Application by Morecambe Offshore Wind Limited for Morecambe Offshore Windfarm Generation Assets

The Examining Authority's additional written questions and requests for information (ExQ3)

Issued on 25 March 2025

LEGEND

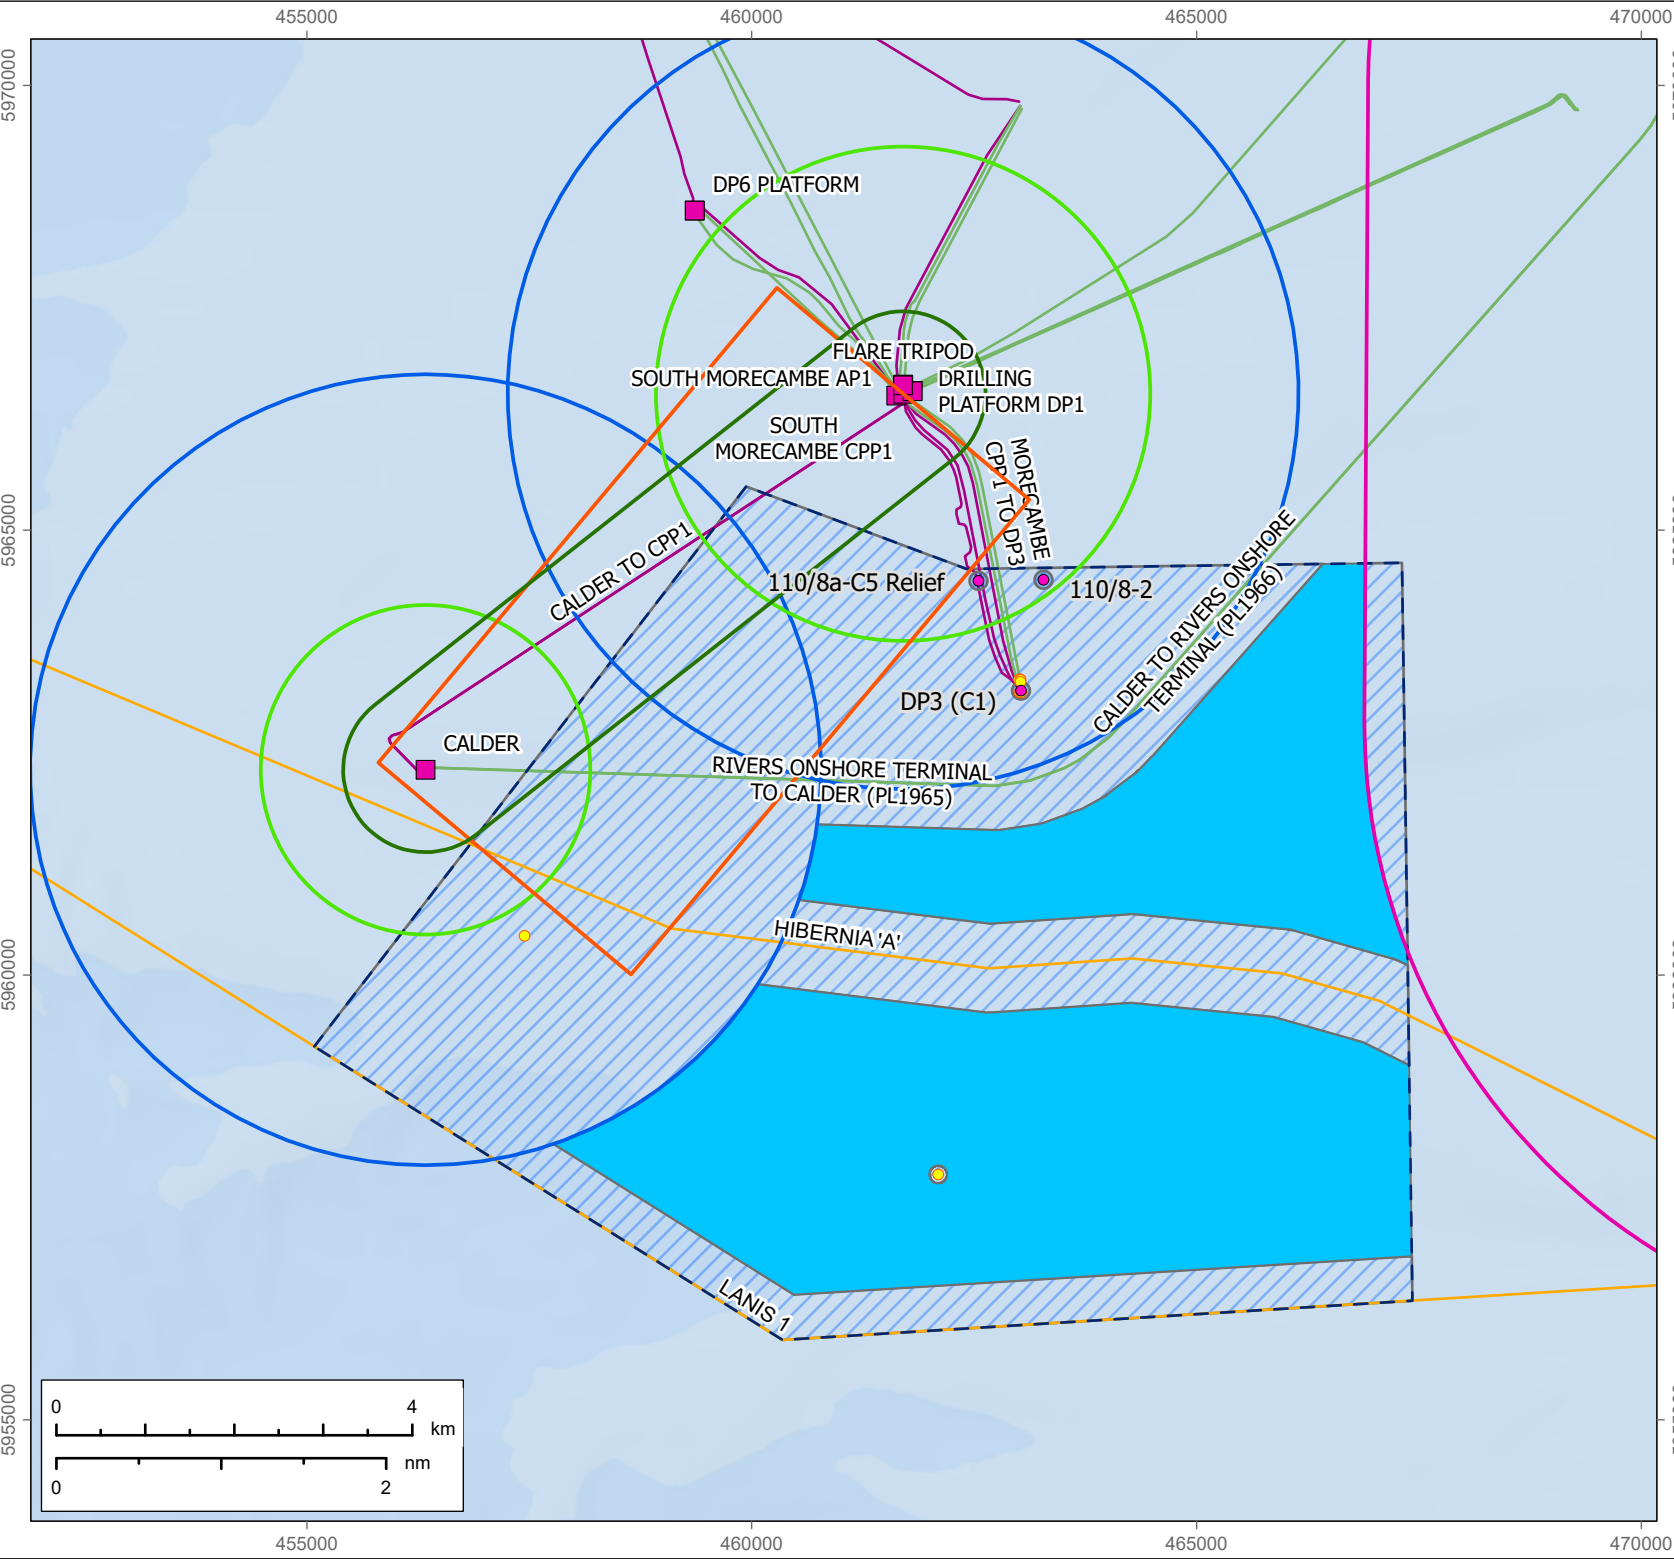
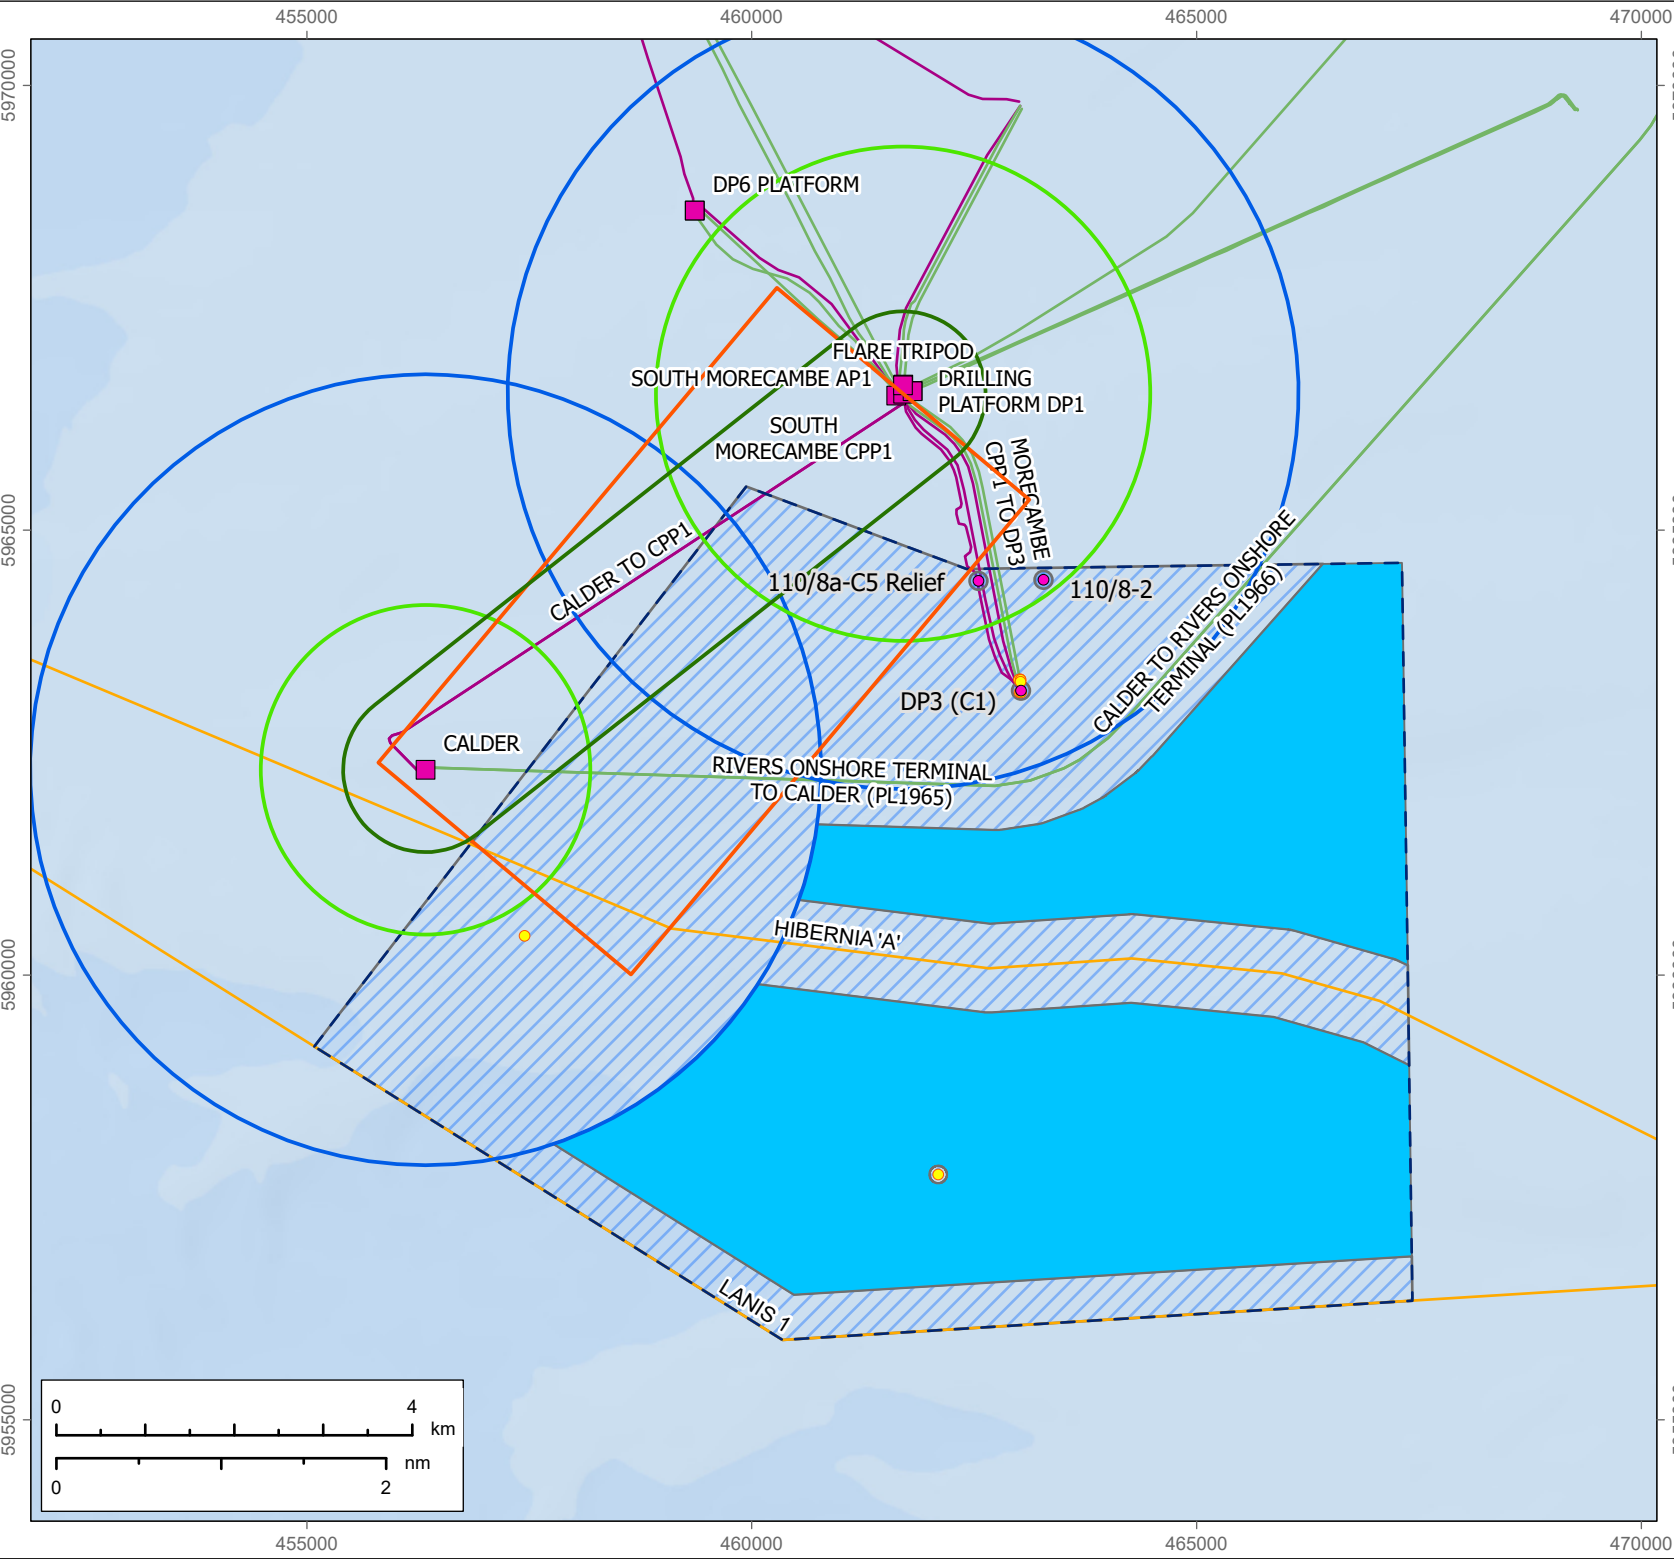
ExQ3	Question to:	Question:										
3GEN3.	The applicant	<p>Liverpool Bay SPA and Oil and Gas Platform Buffers</p> <p>Whilst the ExA notes the caveats stated in the applicant’s response to ExQ2HRA6 at D5 [REP5-070], to further demonstrate and support the applicant’s position:</p> <p>a) please can the applicant provide individual plans to demonstrate the impact that each of the incrementally smaller buffers from the original Liverpool Bay SPA would have on the layout and number of WTGs that could be accommodated within the site (i.e. 10km, 9km, 8km, 7km and so no buffer associated with the SPA affects the site) - with all other existing buffers/ corridors as shown on [REP5-007] unchanged.</p> <p>b) in Spirit Energy’s response to ExQ2CAR5 at D5 [REP5-090] it advises a buffer distance of 1.9nm is the minimum acceptable requirement for safe landing and take-off in daytime VMC and for night VMC this distance would be 2.4nm. In light of this could the applicant provide plans for each alternative SPA buffer scenario in (a) plus each of the increased buffer scenarios from the Calder and CCP1 platforms as set out in the following table.</p>

<table><tr><th><u>CPP1 WTG and OSP Aviation Buffer</u></th><th><u>Calder WTG and OSP Buffer</u></th></tr><tr><td>2.4nm</td><td>2.4nm</td></tr></table>

<p>c) any additional comments or further information the applicant wishes to provide on the implications of each of the above scenarios (noting the applicant’s previous response [REP5-070], EXQ2HRA3 and 2HRA6].</p> <p>The ExA is seeking a complete set of alternative scenarios shown on plans, so that, whatever the SoS may determine, if they felt it was appropriate they could include the relevant plan within any final DCO without having to revert to the applicant for that plan. Each should therefore have a different drawing number.</p>	<u>CPP1 WTG and OSP Aviation Buffer</u>	<u>Calder WTG and OSP Buffer</u>	1.9nm	1.9nm	2.4nm	1.9nm	1.9nm	2.4nm	2.4nm	2.4nm
<u>CPP1 WTG and OSP Aviation Buffer</u>	<u>Calder WTG and OSP Buffer</u>											
1.9nm	1.9nm											
2.4nm	1.9nm											
1.9nm	2.4nm											
2.4nm	2.4nm											
3GEN4.	The applicant	<p>Design Statement - Cabling</p> <p>Could the applicant please explain why (former) provision DC15 relating to use of the most direct/ efficient cabling route to minimise cutting has been deleted from the post-consent design code in Table 6.1 of the Design Statement [REP5-008] and [REP5-009].</p>
